**Town of Addison**  
**Summary of Engineering Review Comments**

Date: December 5, 2019  
 Plan Review : Civil Review 2  
 Received: November 13, 2019  
 Plan Date: November 11, 2019  
 Development: Galaxy FBO

Town Project #:19-09D

SHEET NUMBER  
**C13.02**

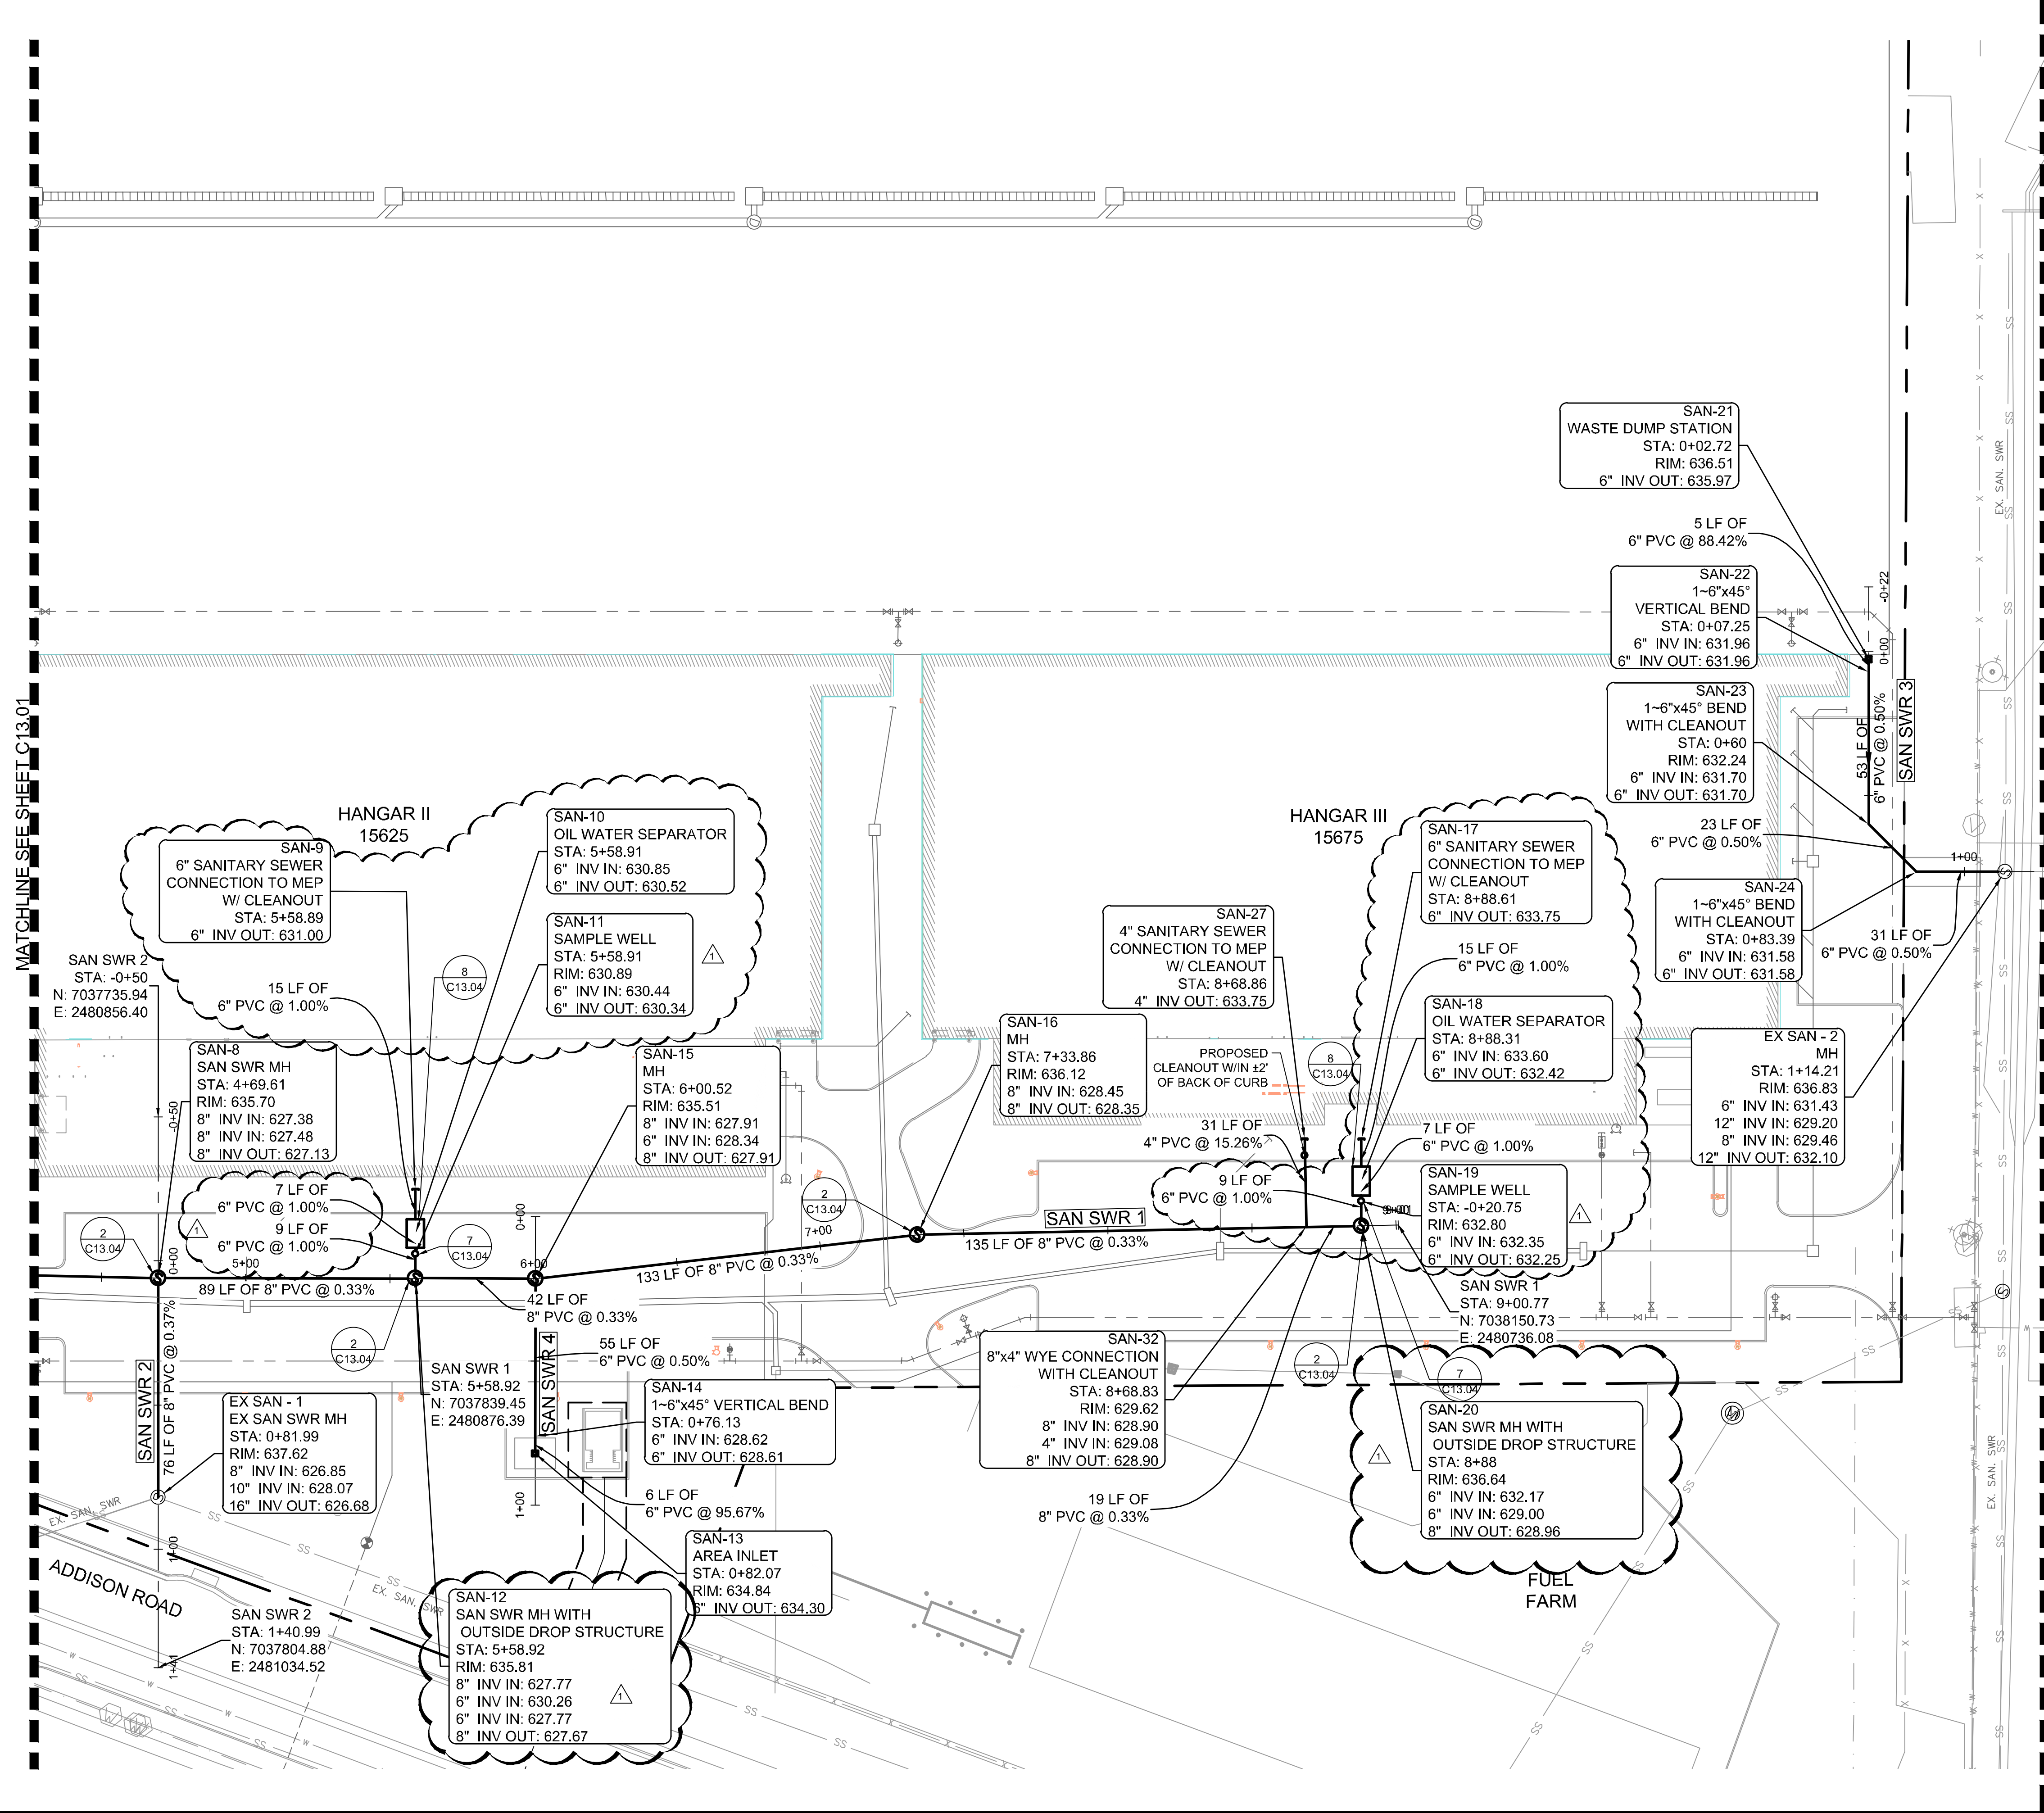
C13.02	Identify SS-4 in plan view	AGREE	SANITARY SEWER 4 IS NOW IDENTIFIED ON SHEET C13.02.
C13.02	SAN-32 : check invert elevations	AGREE	THE INVERT ELEVATIONS OF SAN-32 HAVE BEEN UPDATED.
C13.02	SAN-24 : add w/ cleanout	AGREE	"WITH CLEANOUT" HAS BEEN ADDED TO THE SAN-24 CALLOUT.
C13.04	<b>PREVIOUSLY REQUESTED.</b> TOA has new batch of MH covers that reflect the "new" logo. note that these should be procured from public works. <i>This detail was stapled to the sanitary sewer detail sheet markups provided after Civil Review 1. They were still attached to the markup set when you returned it with the Review 2 submittal. It has been attached again for your use.</i>	AGREE	THE NEW DETAIL HAS BEEN ADDED ON SHEET C13.04, AND A NOTE UNDER THE DETAIL INFORMS THE CONTRACTOR THAT THE MH COVERS ARE TO BE PROCURED FROM TOA PUBIC WORKS.
WATER	<b>PREVIOUSLY REQUESTED.</b> Add valves as noted in the markups & water system requirements (valve on each leg of a tee unless in close proximity to another valve on the same line - deletion of a valve is at staff discretion). <i>Valves on each leg of a tee is a Town of Addison water system requirement and you must comply unless Town staff indicates that a specific location does not need one. Add all valves as requested.</i>	AGREE	THE VALVES HAVE BEEN ADDED AS REQUESTED.

SHEET NUMBER  
**C14.03**

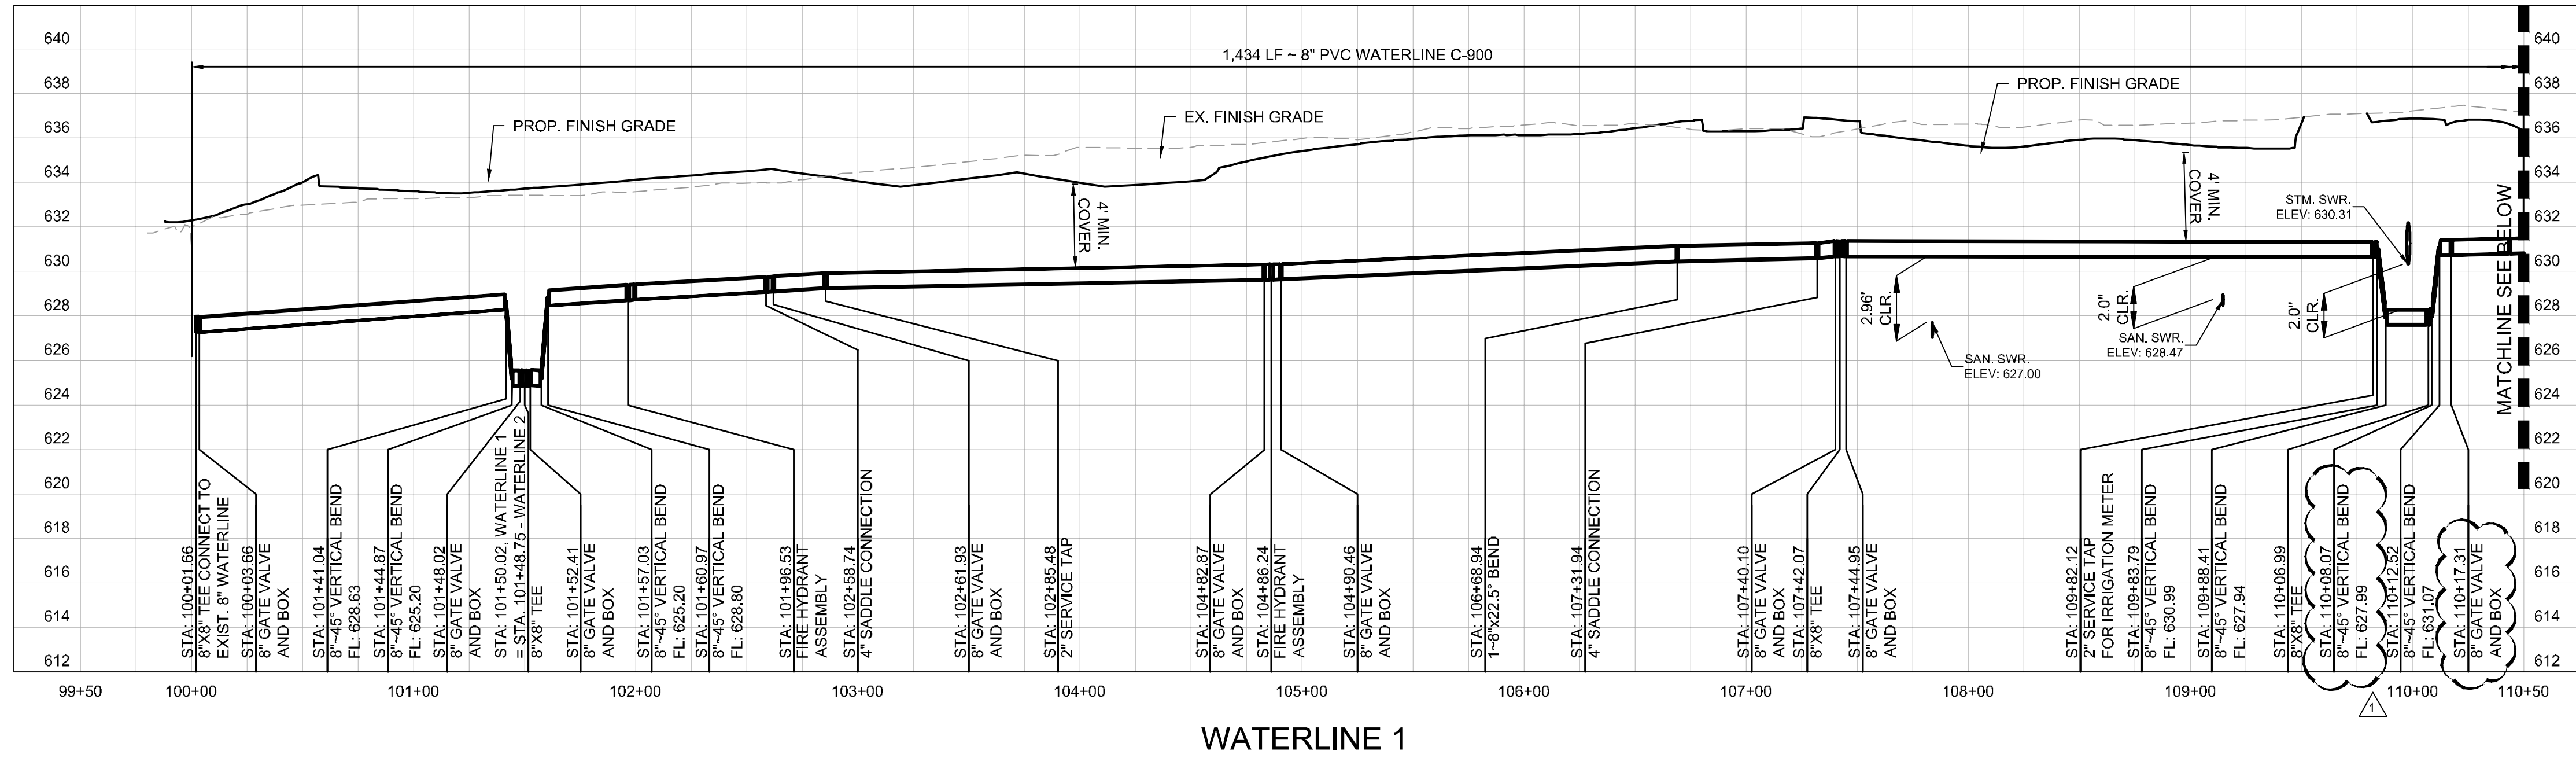
C14.02	Include blow-up detail of service tees & valves for Hangar 2 - placement on the page and proximity of the two services makes it hard to properly identify correct assembly.	AGREE	SEE SHEET C14.03, WATERLINE BLOW UP PLAN.
C14.02	Include a detail for the existing water line connection at Addison Rd - it is difficult to see what's happening b/c it's right on the match line.	AGREE	SEE SHEET C14.03, WATERLINE BLOW UP PLAN FOR THE EXISTING WATER LINE CONNECTION.
C14.02 & C14.04	WL-5 should be WL-4?	AGREE	WATERLINE CALLED HAVE BEEN CHANGED FROM "WL-5" TO "WL-4".

Page No.	Comments	Response (See Note)	Explanation
C14.03	WL-2 profile has labels calling out WL-1 and is not showing the storm drain crossing.	AGREE	THE WATER LINE HAS BEEN SHIFTED EAST, AWAY FROM THE STORM DRAIN, THEREFORE THERE IS NOW ENOUGH HORIZONTAL DISTANCE TO MAKE THE NECESSARY VERTICAL CHANGES.
C14.04	WL-3 STA 300+50 does not have a label, but does have a revcloud. ???	AGREE	THE LABEL FOR WL-3 HAS BEEN ADDED.
C15.00	Where are elec/telco/fiber/etc service connections & lines? Will there be transformers/cabinets/pedestals/meters, etc onsite that will need locations coordinated with other infrastructure & landscaping?	AGREE	<p>PRIMARY ELECTRIC CONNECTION AND CONDUIT TO THE TRANSFORMER/EQUIPMENT AREA ARE SHOWN ON SHEET C15.00. THE TRANSFORMERS/CABINETS/PEDESTALS/METERS, ETC. ARE IN THIS TRANSFORMER/EQUIPMENT AREA.</p> <p>TELECOM/FIBER SERVICES ARE BEING DESIGNED BY A LOW VOLTAGE CONSULTANT SO A NOTE HAS BEEN ADDED ON THIS SHEET INSTRUCTING THE CONTRACTOR THAT THEY HAVE TO REFER TO THAT CONSULTANT'S PLANS FOR THAT INFORMATION.</p>

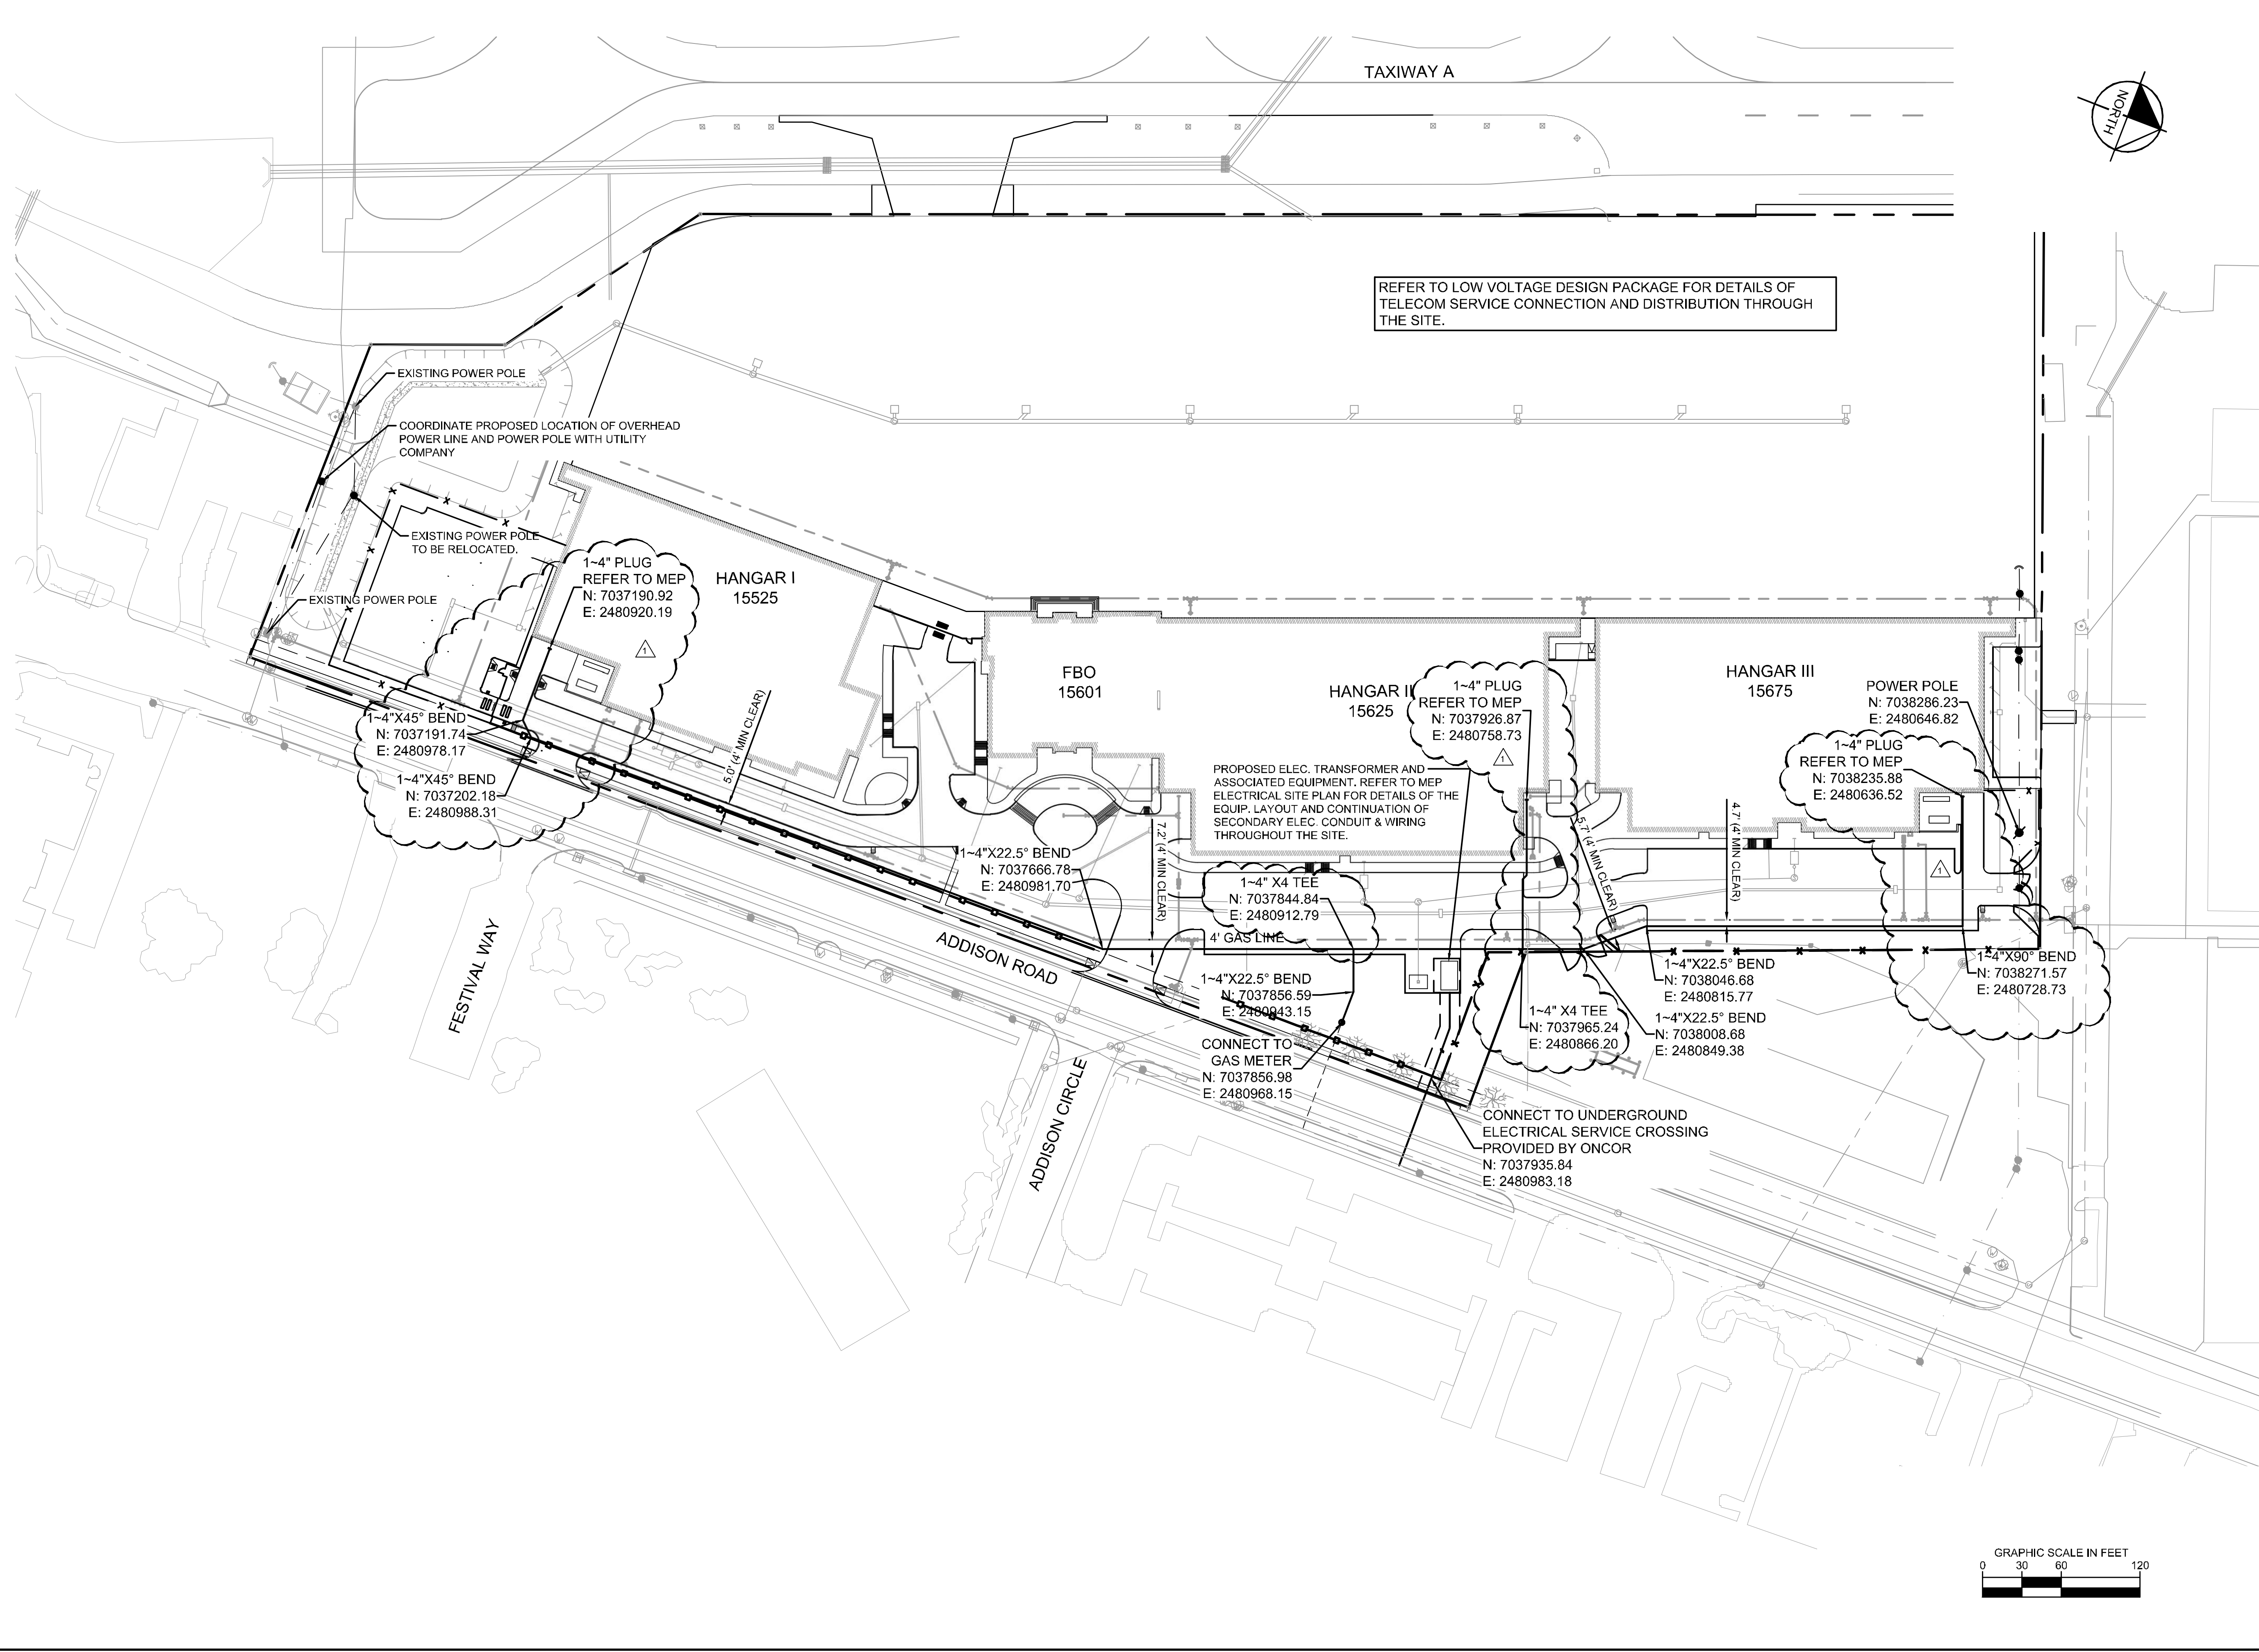
C15.00 & C18.01	Show southern property line power pole relocation on this sheet, not C18.01	AGREE	POWER POLE RELOCATION NOTE HAS BEEN MOVED FROM SHEET C18.01 TO SHEET C15.00

Page No.	Comments	Response (See Note)	Explanation
C15.00	Is the one electrical service called out on the sheet the only electrical connection you will have? Where does the elec conduit run within the site? This service crossing needs to be identified/labeled as an underground crossing. Is the aerial crossing on the north side of the northern drive still necessary? If so, call for undergrounding the service line.	AGREE	<p>THE ONE PRIMARY ELECTRICAL SERVICE SHOWN ON THIS SHEET IS THE ONLY ELECTRICAL CONNECTION.</p> <p>THE MEP IS RESPONSIBLE FOR THE SECONDARY CONDUIT WITHIN THE SITE, SO A NOTE HAS BEEN ADDED ON THIS SHEET INSTRUCTING THE CONTRACTOR THAT THEY HAVE TO REFER TO THE MEP'S PLANS FOR THAT INFORMATION.</p> <p>THE AERIAL CROSSING HAS BEEN NOTED TO BE REMOVED ON THE DEMO PLAN, AND THEREFORE, IT NO LONGER APPEARS ON THE REST OF THE PLANS.</p>
C15.00	<b>PREVIOUSLY REQUESTED.</b> Dimension the separation from the water & gas (min. 4')	AGREE	ALL GAS LINES ARE NOW A MINIMUM OF 4' AWAY FROM WATER LINES.
